CITY OF ALBUQUERQUE

**Re: West ABQ Self Storage
99999 Woodmont NW (Paseo Del Norte & Woodmont)
Conceptual Traffic Circulation Layout for DFT Approval
Engineer's Stamp 8-1-25 (C09D022) TRANS-2025-00212**

SITE PLAN EXHIBIT

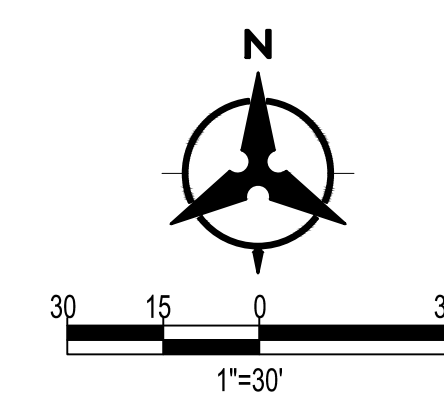
1-A 6 ft sidewalk, and 5-6 ft Landscape/Buffer along Paseo Del Norte is shown on the TCL plan

2- A 5 ft sidewalk, and 4-6 ft Landscape/Buffer along Woodmonte is shown on the TCL plan
3- A 5 ft sidewalk, and 4-6 ft Landscape/Buffer along Unnamed road on the south is shown on the TCL plan.

4-All the above infrastructures should be added to the IIA list and financially guaranteed.
